From: Tim Townsend [REDACTED]
Sent: 05 March 2018 11:05
To: Planning.Responses
Cc: Michael Eastham; Gary Markwell; Juliet Harris [REDACTED]
Subject: LU/278/17/RES - Southern By-Pass, Toddington - Approval of reserved matters - WSCC Highways response dated 5th March 2018

WEST SUSSEX COUNTY COUNCIL
PLANNING SERVICES CONSULTATION

SUBJECT: LU/278/17/RES - Approval of Reserved Matters following Outline Permission LU/47/11 for Construction of the southern section of the Lyminster Bypass, including northern and southern roundabouts, surface water drainage and landscaping. Departure from the Development Plan & affects a Public Right of Way.

LOCATION: North Littlehampton Strategic Development Site, Land West of Toddington Park, Toddington Lane, Littlehampton, BN17 7PP.

Landscape SLB4.1
Proposals: Southern
Roundabout (showing drainage
and visibility splays)

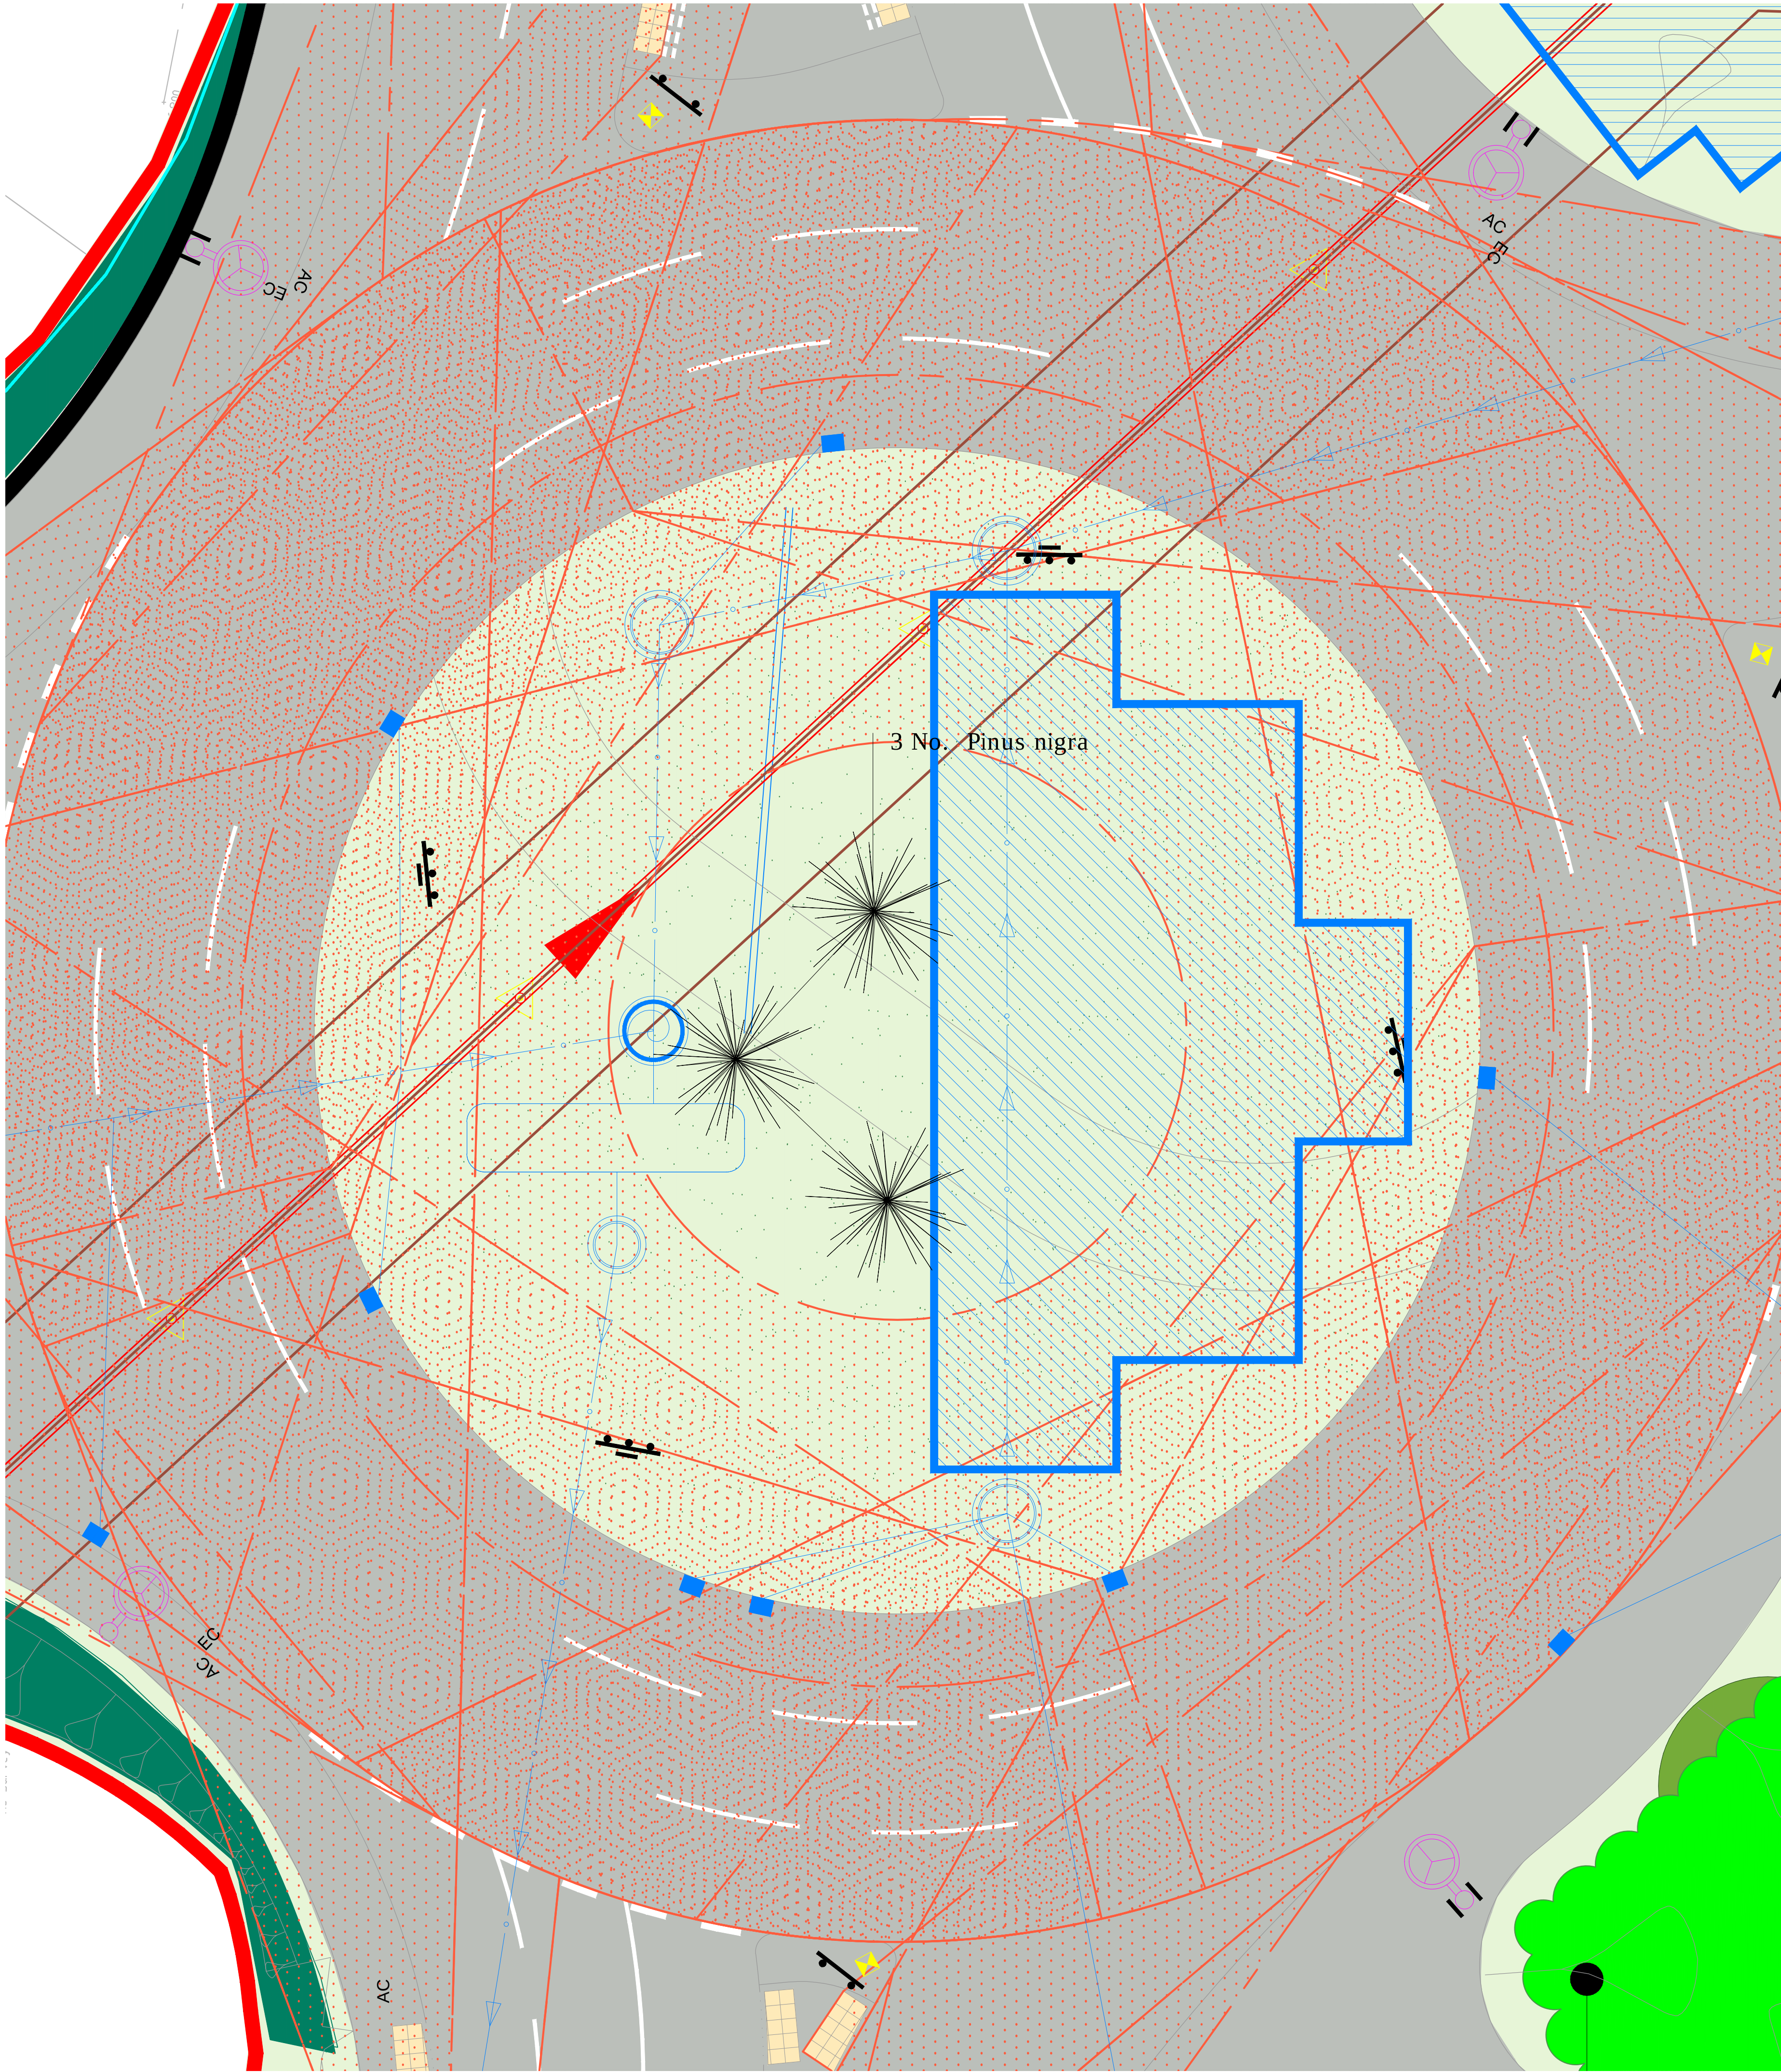
- The footway on the NE corner of the A259 roundabout, forming part of the Persimmon design, will need to have adequate visibility provided to assist pedestrians crossing the road and that are visible to passing traffic. Likewise, the proposed planting at this location will also need to be looked at very carefully to ensure it doesn't encroach on any necessary visibility splays nor the carriageway itself. Please provide further information. The applicant has responded by saying that TD16/07 Para 8.12 indicates that *"At the give way line, drivers must be able to see the full width of a pedestrian crossing (whether signal-controlled, zebra or informal) across the next exit if it is within 20m of the give way line on that arm (crossings should not be sited between 20m and 60m from the give way line)."* This is achieved with the current design arrangements. This will be reviewed again at the S38/278 detailed design stage.
